Dear Mr Ely

Please see my response to ExA 2nd set of questions:

Q2.2.1 and Q2.2.2

Figure 9-8-1 to 9-8-4. Distribution of non-breeding bird species of conservation concern

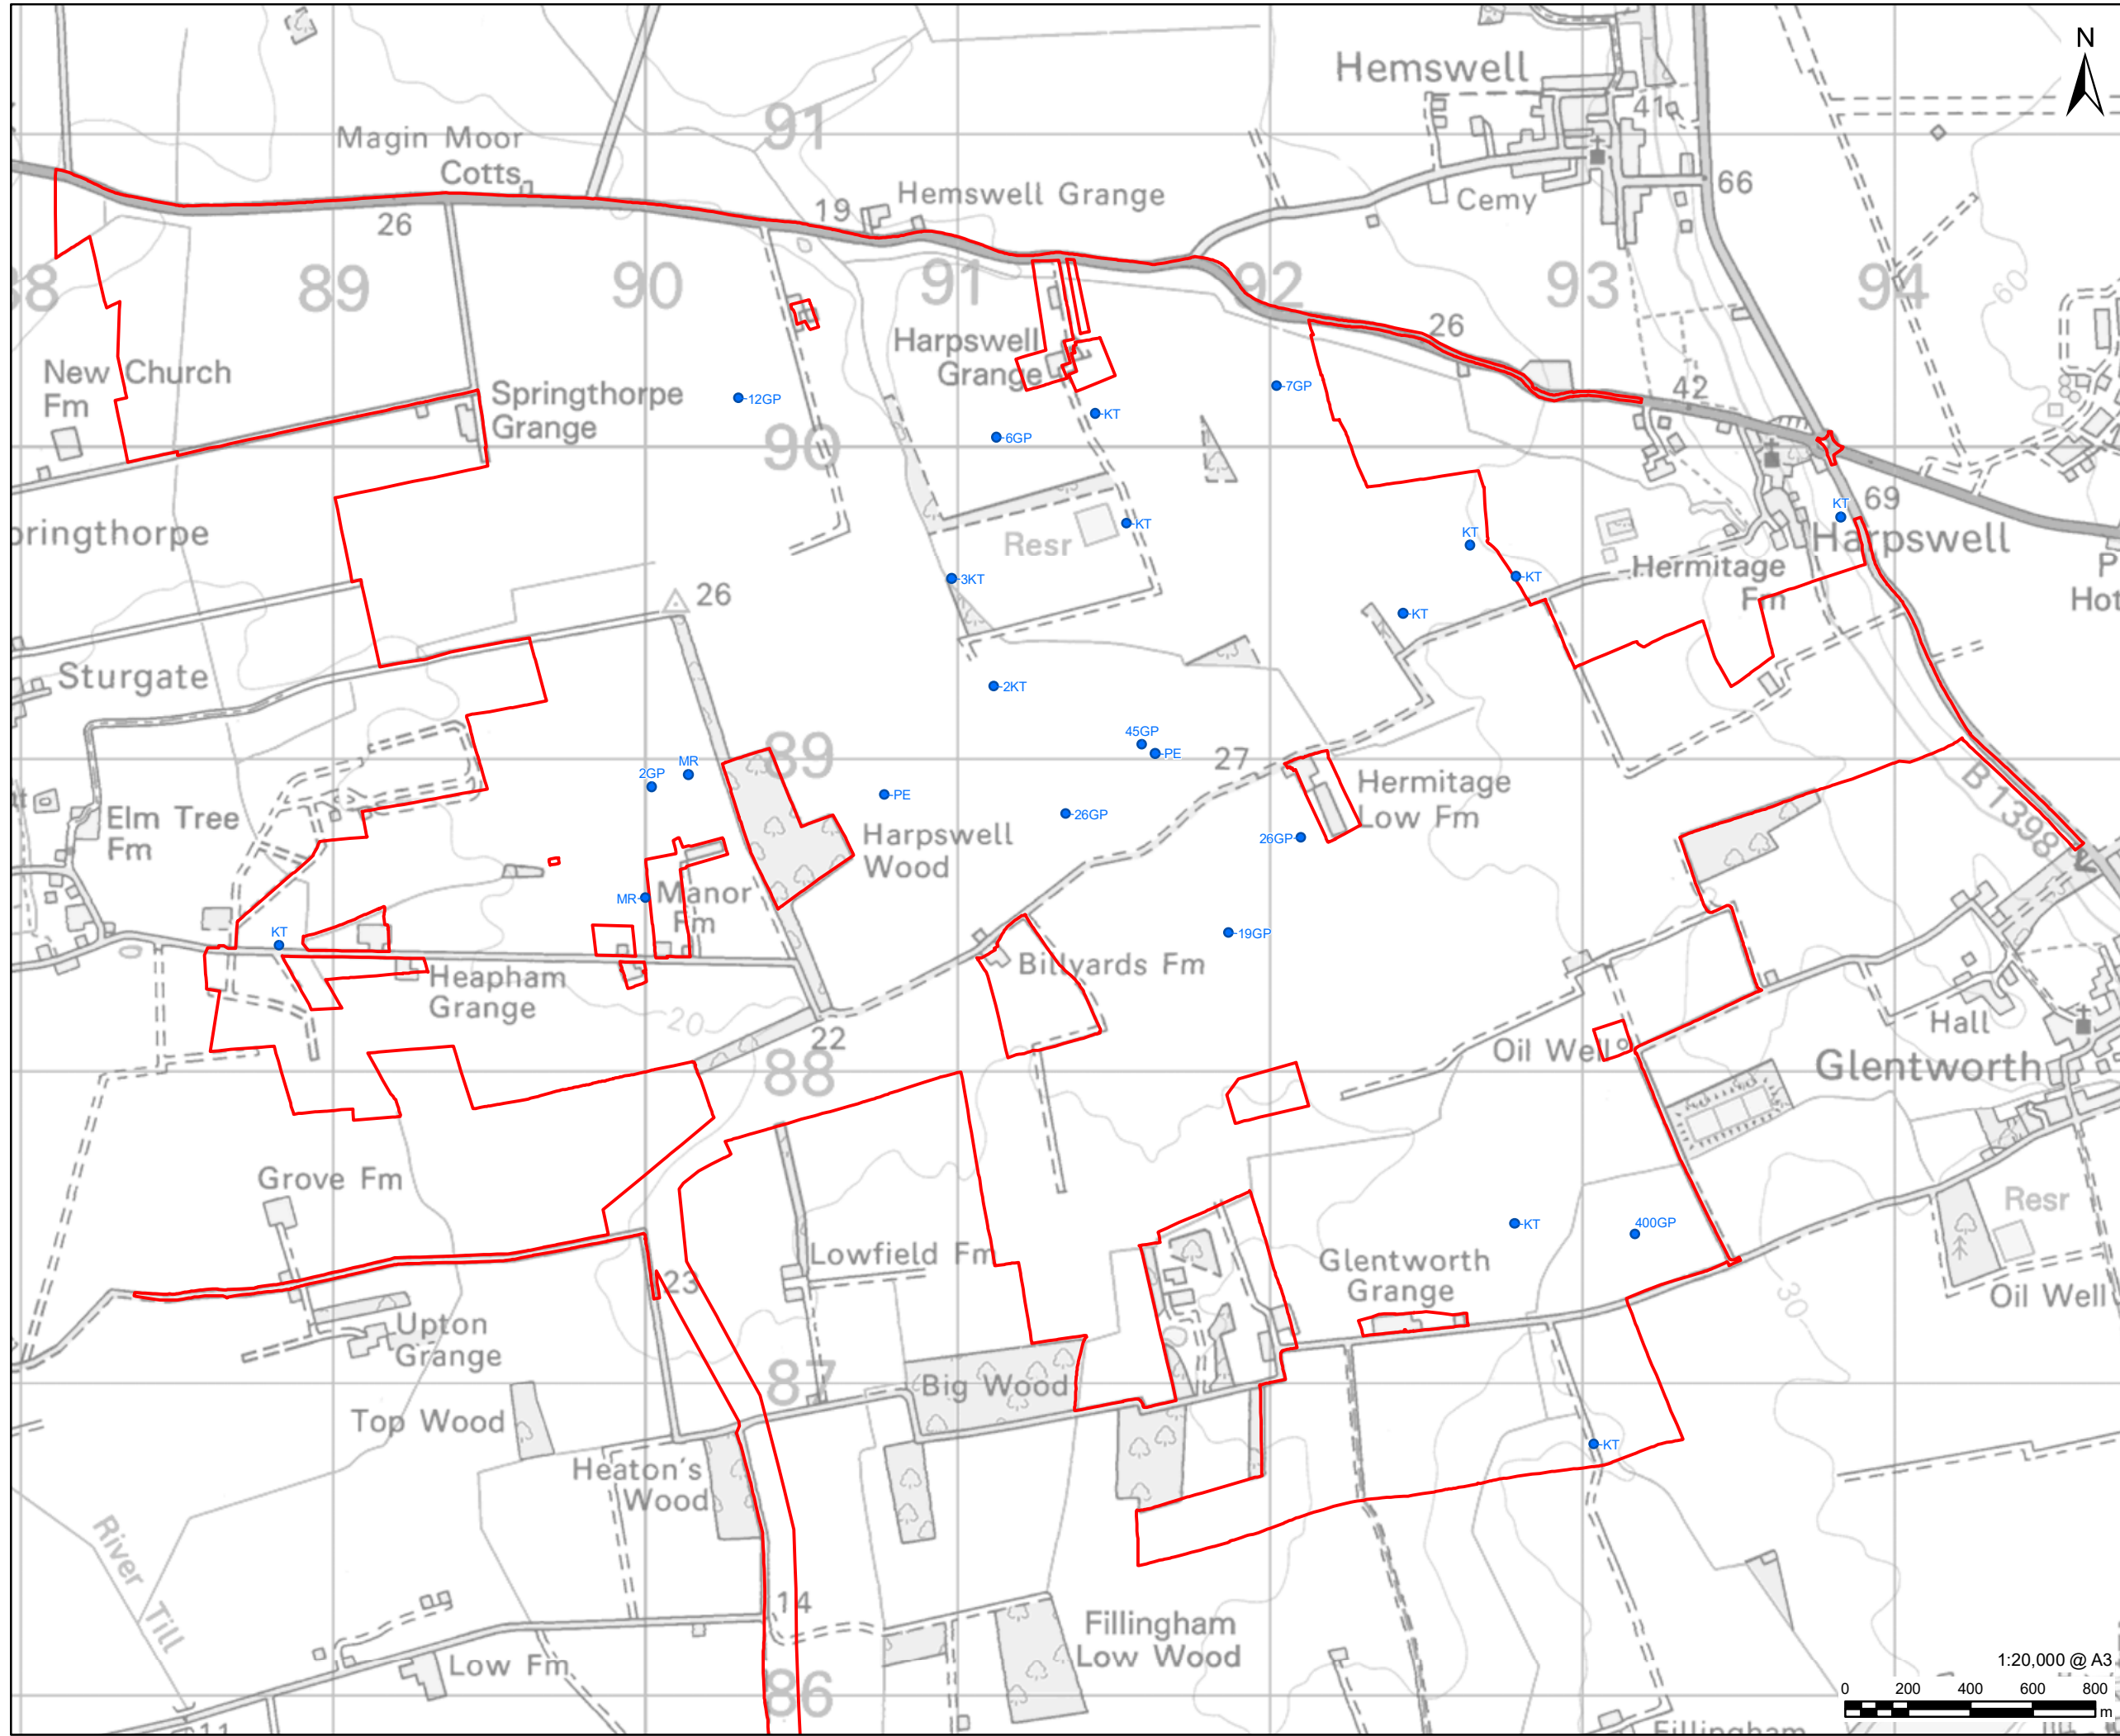
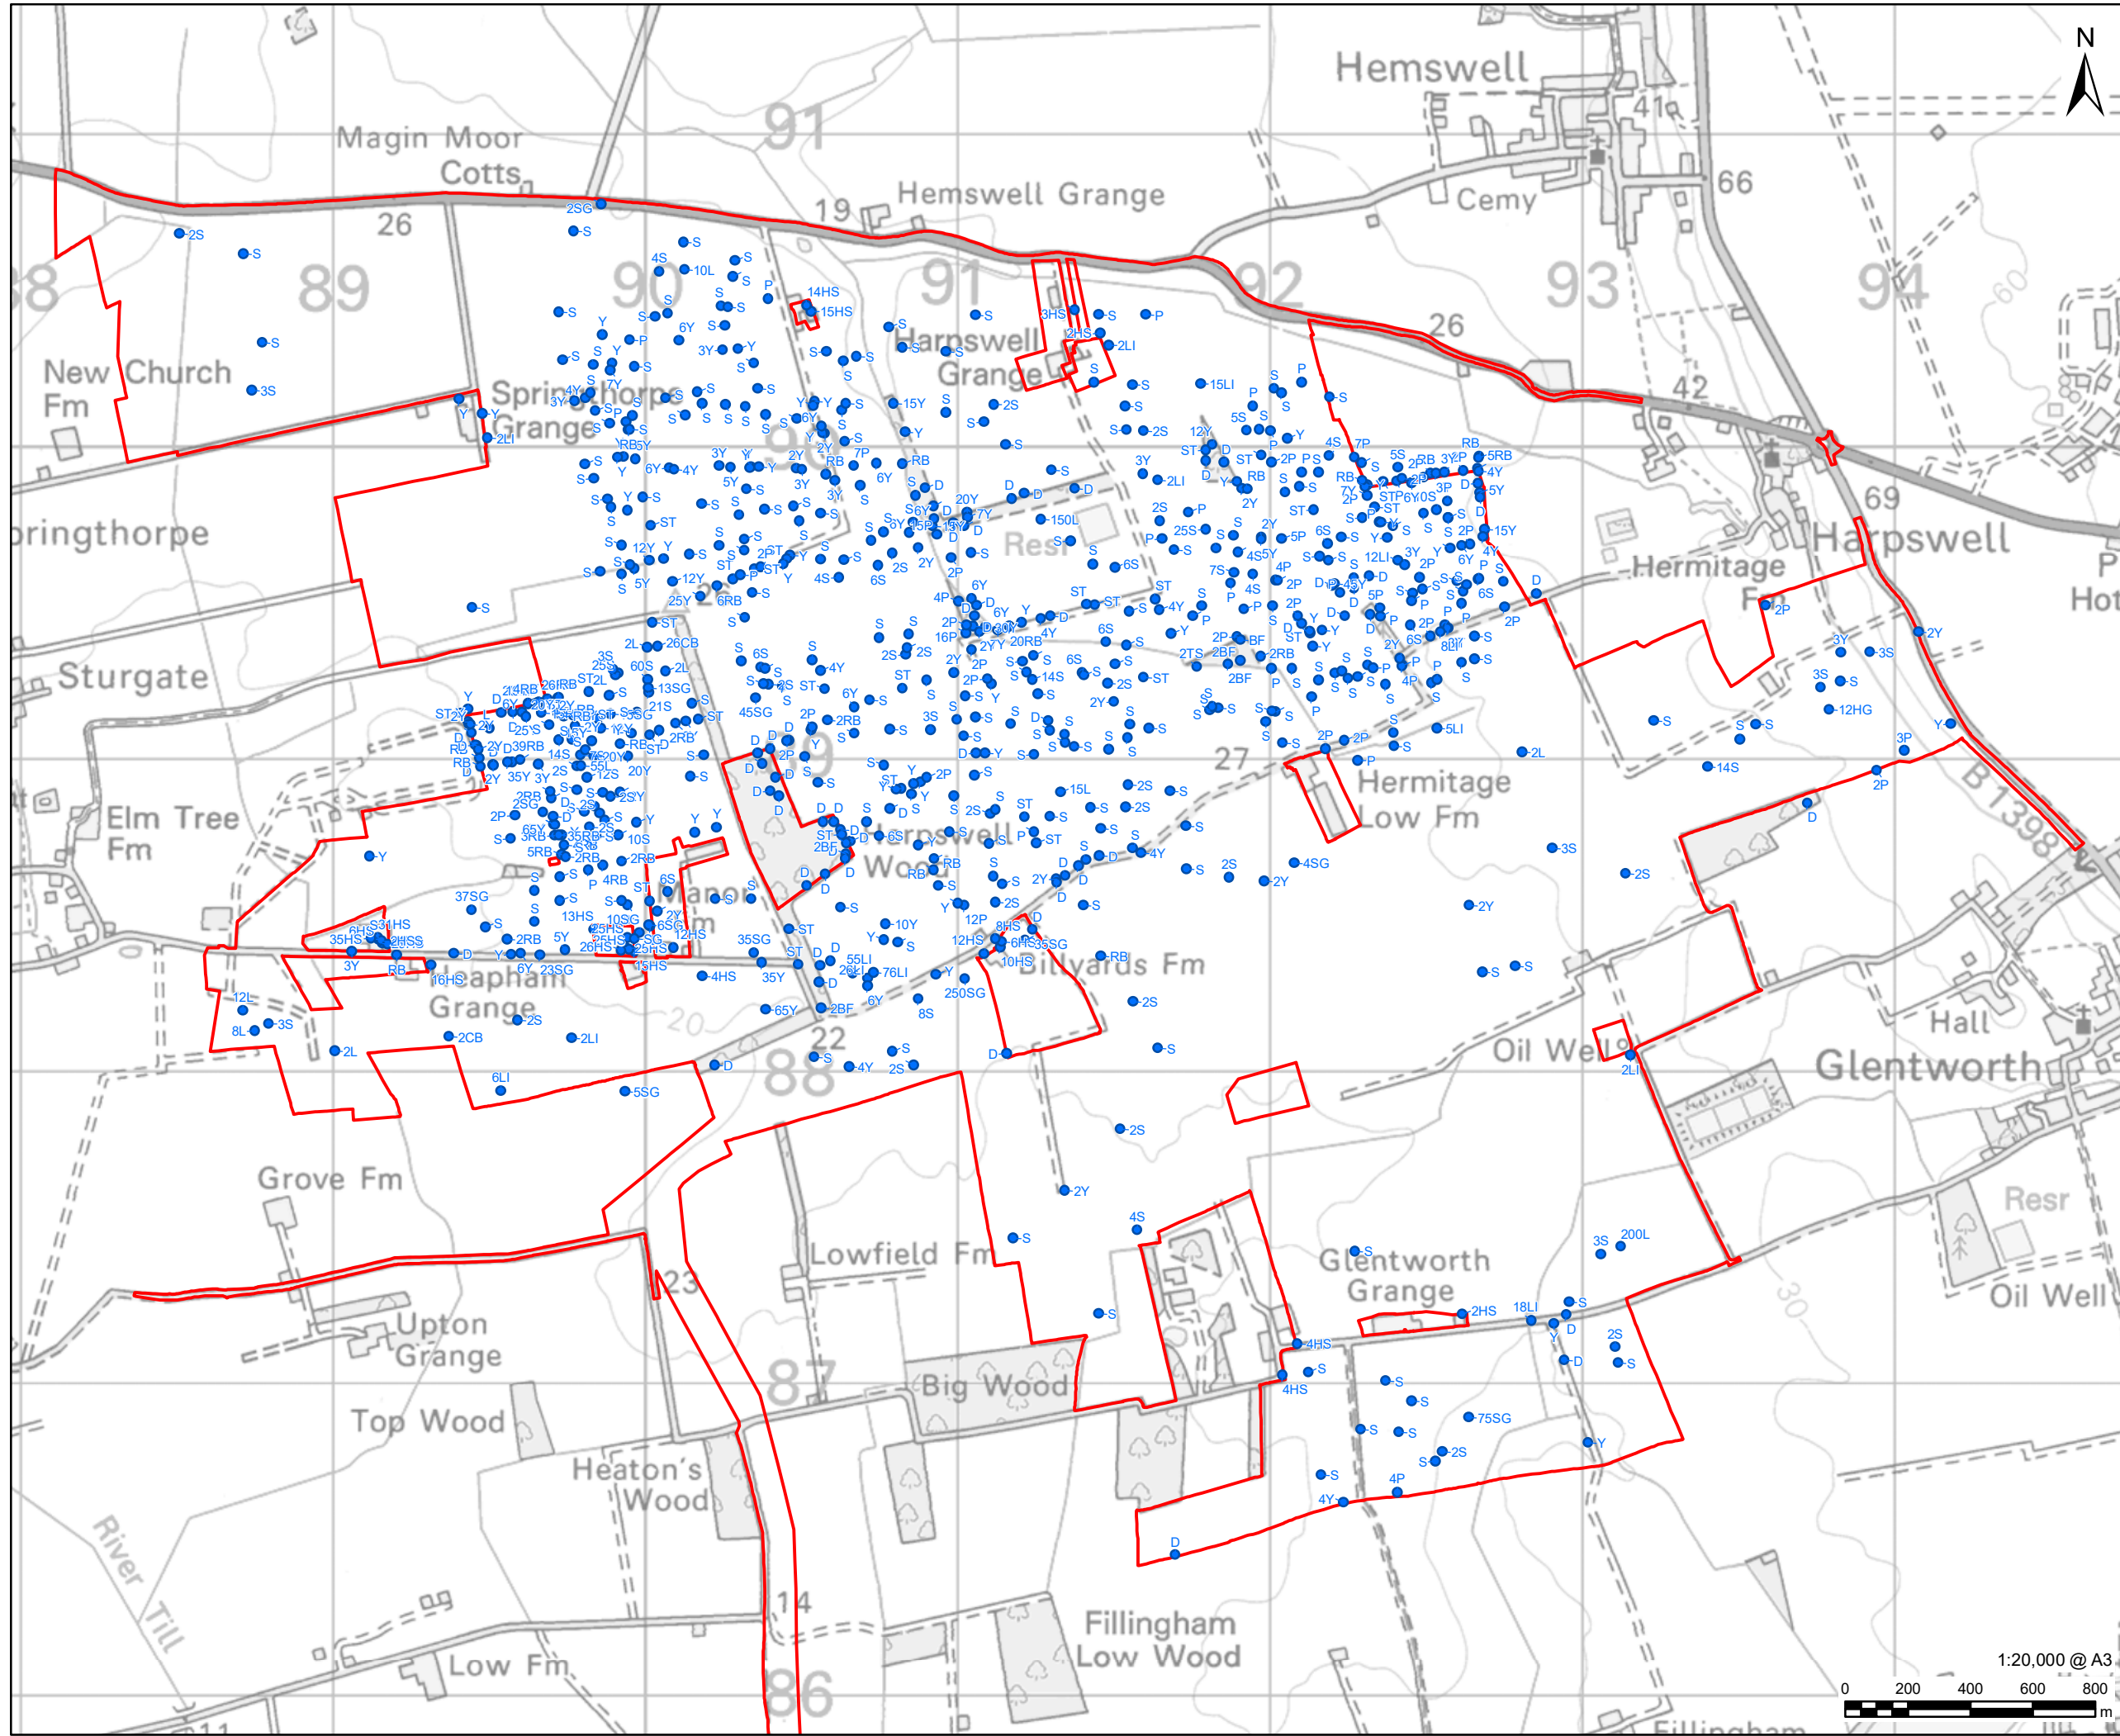
“Barn Owl”

EN010142-000271-6.2%20Appndx%209-8%20Baseline%20Report%20for%20Non-Breeding%20Birds.pdf

There has been a concentrated effort to enable Barn Owls to increase their population with the installation of Barn Owl breeding boxes along the length of the [REDACTED], Lincolnshire. These have been successful and Barn Owls have been noted breeding in the locations where boxes have been installed. Adult Owls have been observed hunting to feed their young in the immediate vicinity of [REDACTED]. The inclusion of Barn Owl in the non-breeding birds report is incorrect.
